Ribble Valley Borough Council  
Housing & Development Control

Your ref: 3/2022/0909  
Our ref: D3.2022.0909  
Date: 21<sup>st</sup> October 2022

Application no: **3/2022/0909**

Proposal: **Change of use of three adjoining steel portal frame agricultural structures to five dwellings under Class Q (a) and (b) of the GPDO.**

EXISTING LOCATION PLAN
1:1250

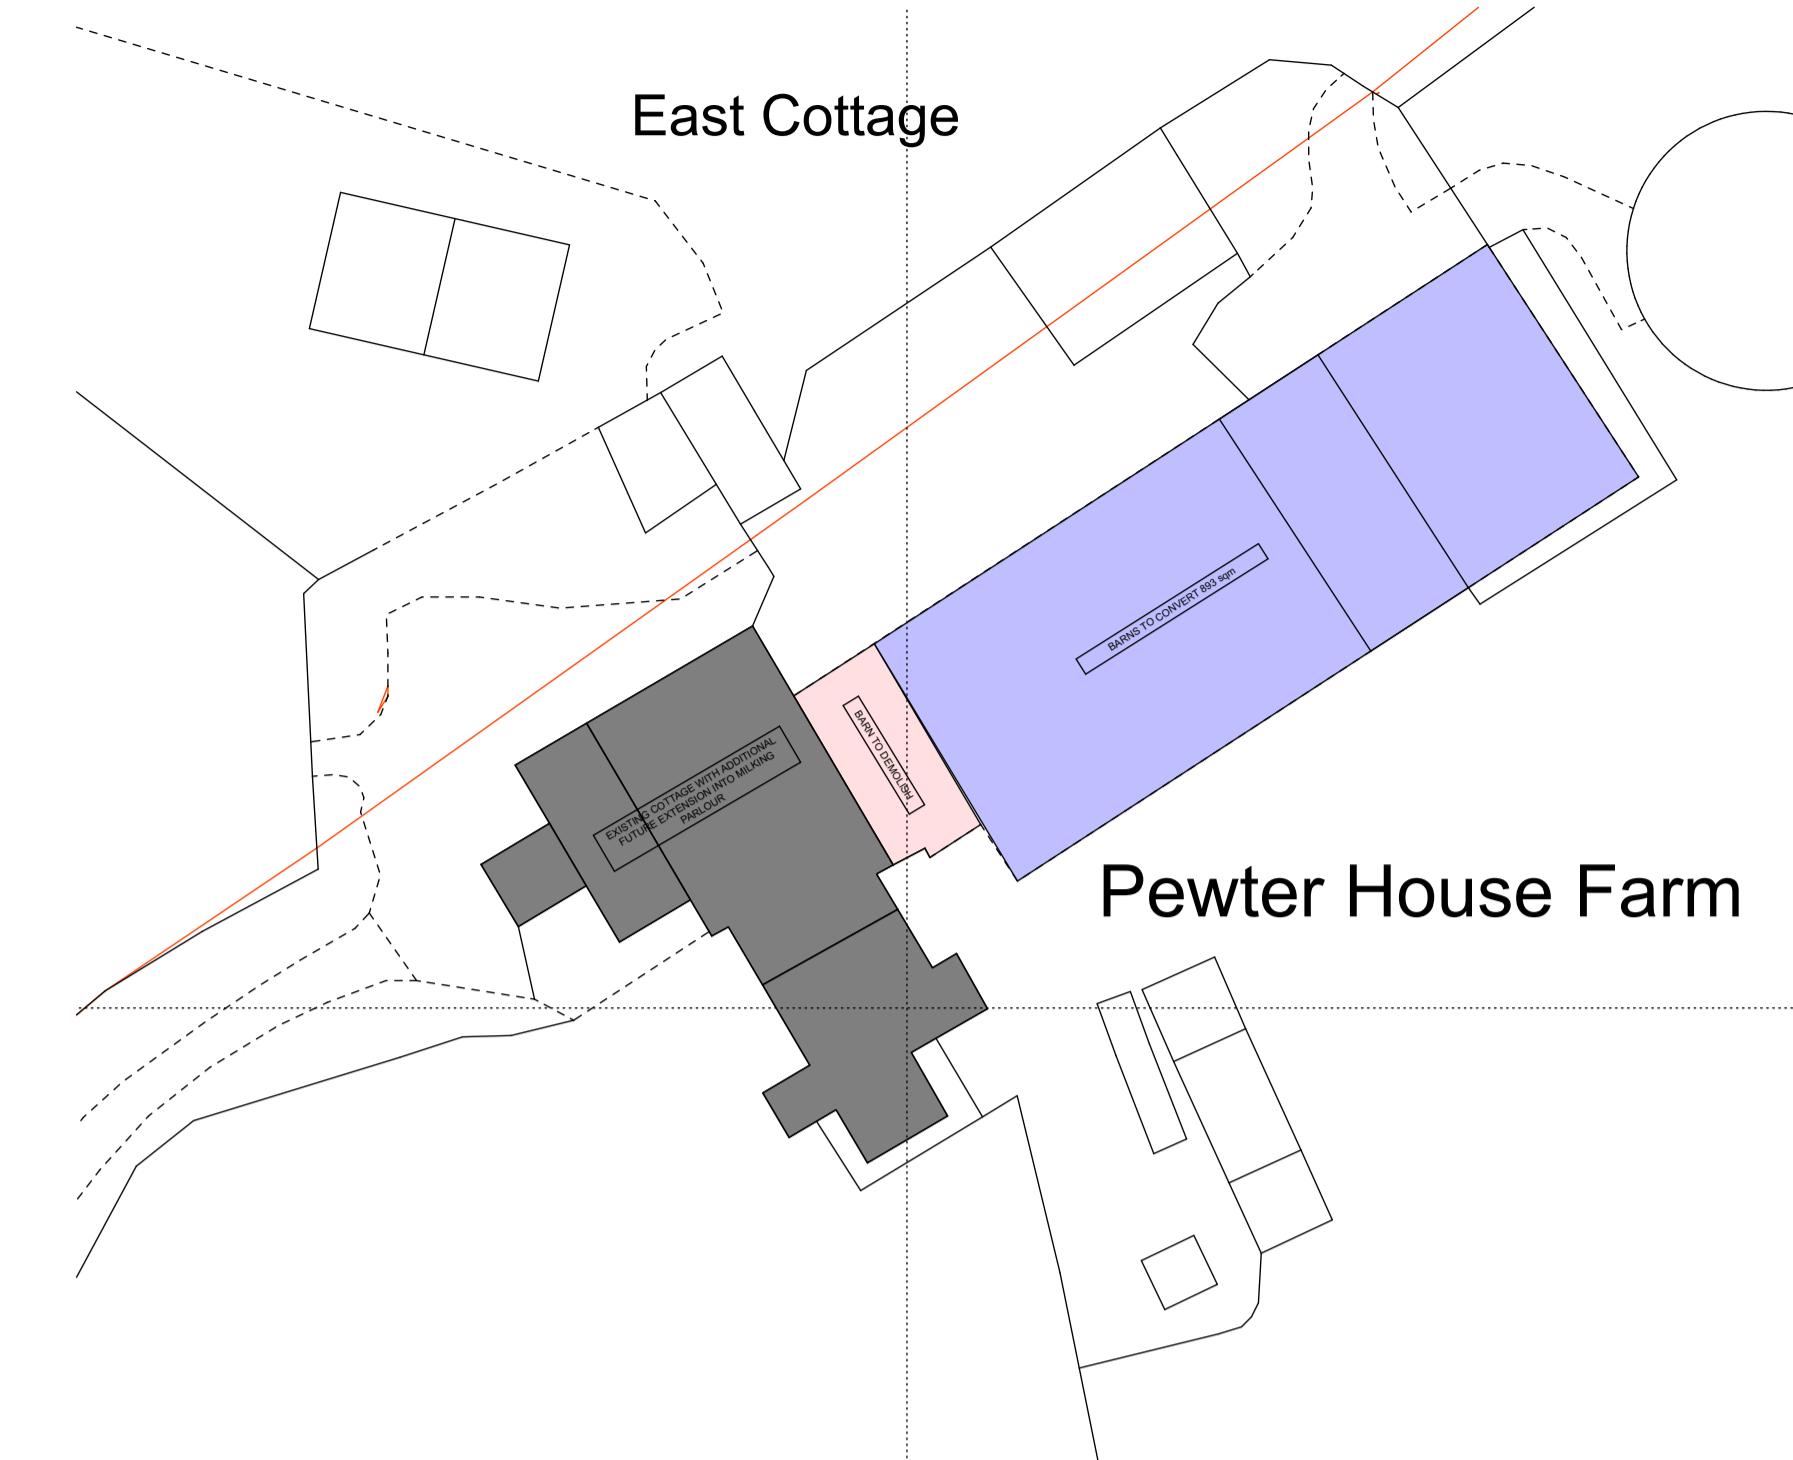
The LHA have reviewed the supporting documents and understands that a drawing has not been submitted which shows the full length of Carr Lane and the access onto Commons Lane.

However, the LHA have reviewed the access by analysing Mapzone, the digital mapping software used by Lancashire County Council, Google Streetview which has images of the access generated from May 2011 and conducted a site visit on 19<sup>th</sup> October 2022 and found that the access is unlikely to achieve the minimum visibility splays for a 30mph speed limit. This is due to the vegetation on both sides of the access, which includes two highway trees located within the highway verge to the left of the access, providing obstructions within the access's visibility splays. Therefore, due to these obstructions, the LHA are concerned that the proposal will intensify the use of a substandard access.

Furthermore, the LHA are aware by using Mapzone, Google Streetview and conducting a site visit, that the access width is also inadequate for the intensification of use. This is because the LHA normally require an access serving numerous dwellings and agricultural holdings to be a minimum of 6m wide for a distance of 10m behind the highway boundary. However, by reviewing Mapzone, the width is approximately 5m wide, but the mapping software does not take into account the verge which is located on both sides of the access track, meaning that the access width is much less than advertised. Therefore, the LHA are aware of the likely shortfall and so are concerned that the proposal will intensify the use of a substandard access.
